DOC18/521407-1
SSD 7142

United Wambo Open Cut Coal Mine Project (SSD 7142) – Response to IPC Review

United Wambo Open Cut Coal Mine Project (SSD 7142) – Response to Independent Planning Commission Review

Figure 10-5: Jerrys Plains Biodiversity Stewardship Site Biodiversity Features

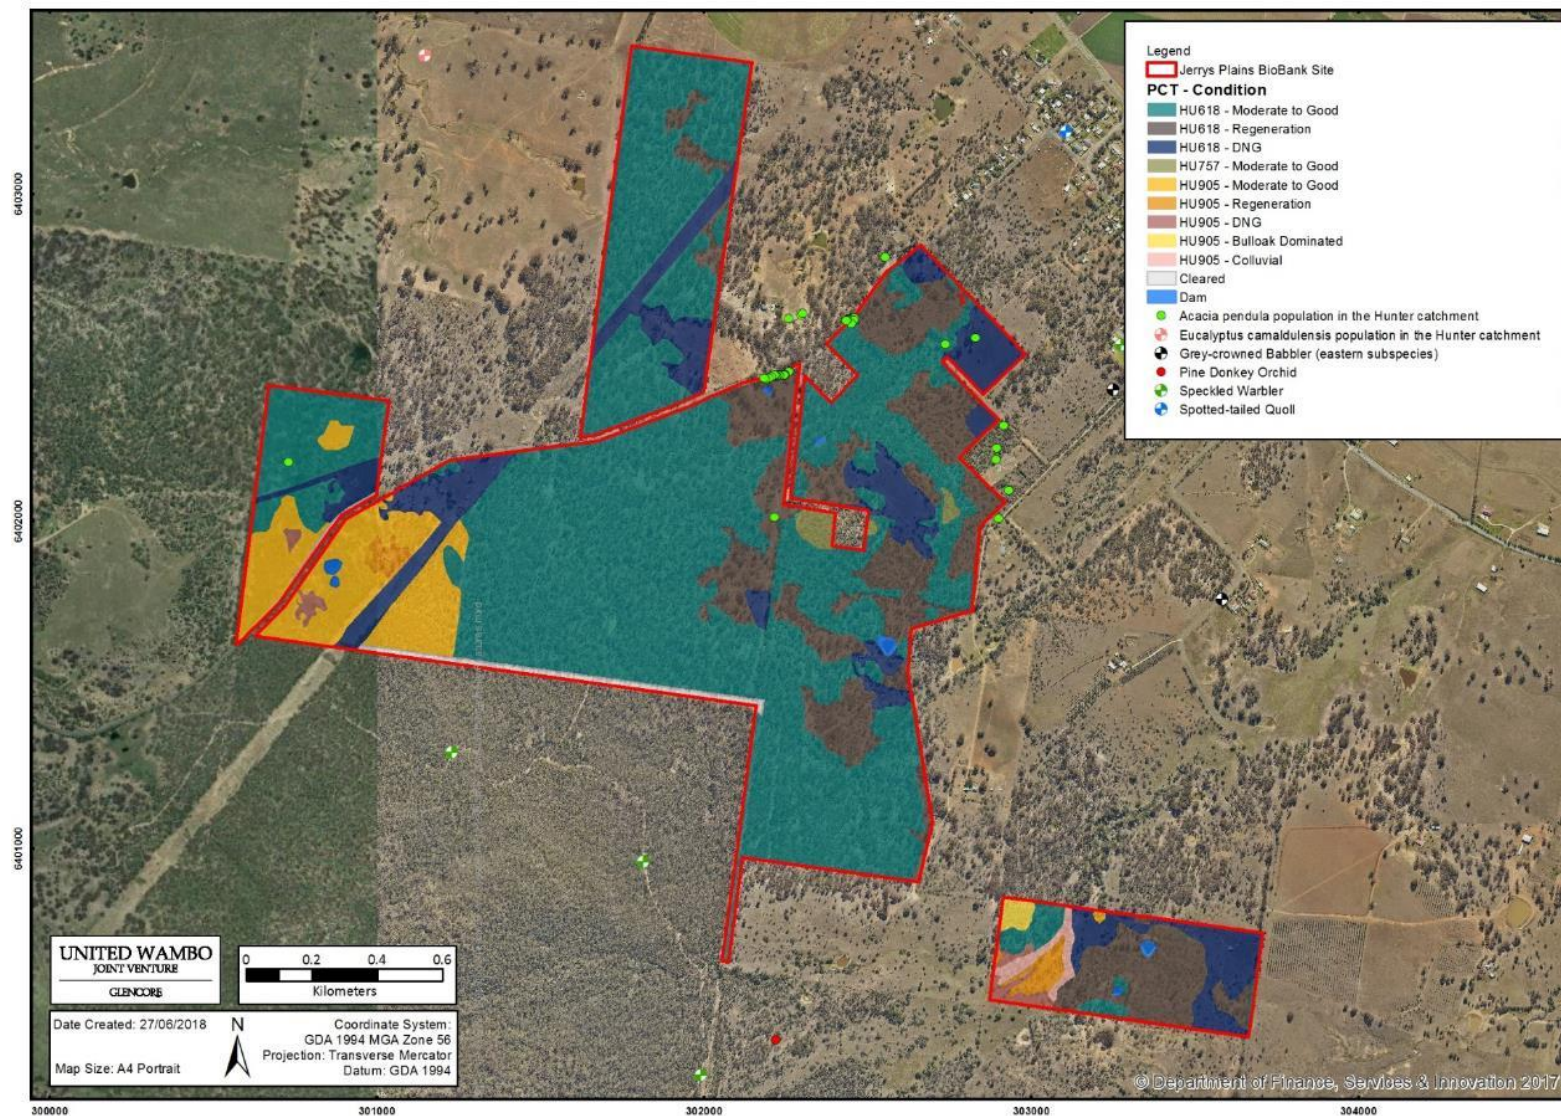
Vegetation Zone 3 of the Jerrys Plains Offset (Slaty Box – Grey Gum shrubby woodland on footslopes of the upper Hunter Valley, Sydney Basin Bioregion) in its current state scores zero (out of three) due to a lack of native shrub cover. The 'score with management' value in the credit calculator for shrub cover increases, by default, to a value of 1.0 for an offset site based on assumed natural recruitment.

However, with active planting, as proposed for this vegetation zone, the 'score with management' should be increased to a default of 1.5. Instead it has been set to zero. Correcting this 'score with management' value will generate some extra ecosystem credits for this vegetation zone when the credit calculator is re-run.

OEH recommends that the 'score with management' value for 'native ground cover (shrubs)' for Vegetation Zone 3 for the Jerrys Plains offset is set to 1.5 and the credit calculator is re-run.

Figure 10-6: Brosi Biodiversity Stewardship Site Biodiversity Features

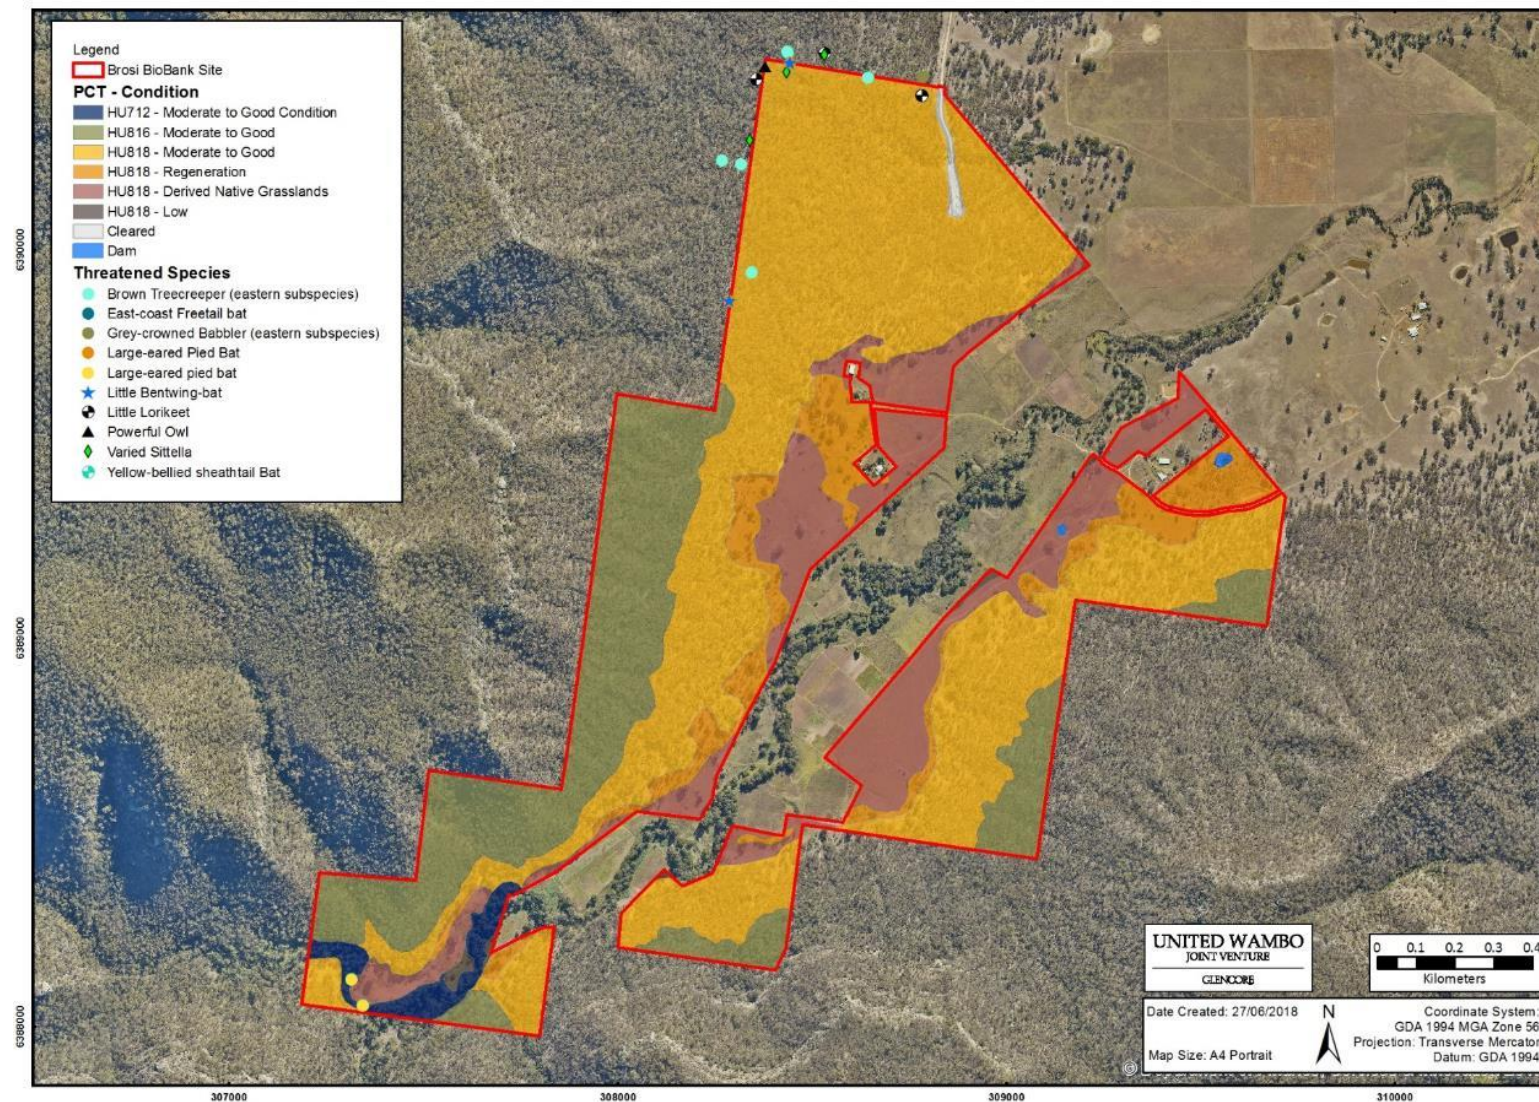
Vegetation Zones 3 (HU818 Moderate/Good condition) and 4 (HU818 Moderate/Good_other) on the Brosi offset have contrasting woody vegetation cover, with Vegetation Zone 3 covering relatively intact forest whereas Vegetation Zone 4 is a derived grassy woodland that has been heavily modified by human activity. OEH has identified about five hectares along the lower margin of vegetation Zone 3 that appear more appropriately mapped as Vegetation Zone 4 (See **Figure 1**, below).

OEH recommends that the proponent reviews the mapping of vegetation zones 3 and 4 and considers mapping the areas shown in figure 1 as additional areas of zone 4. Any change to the area of vegetation zones will require the credit calculator to be re-run.
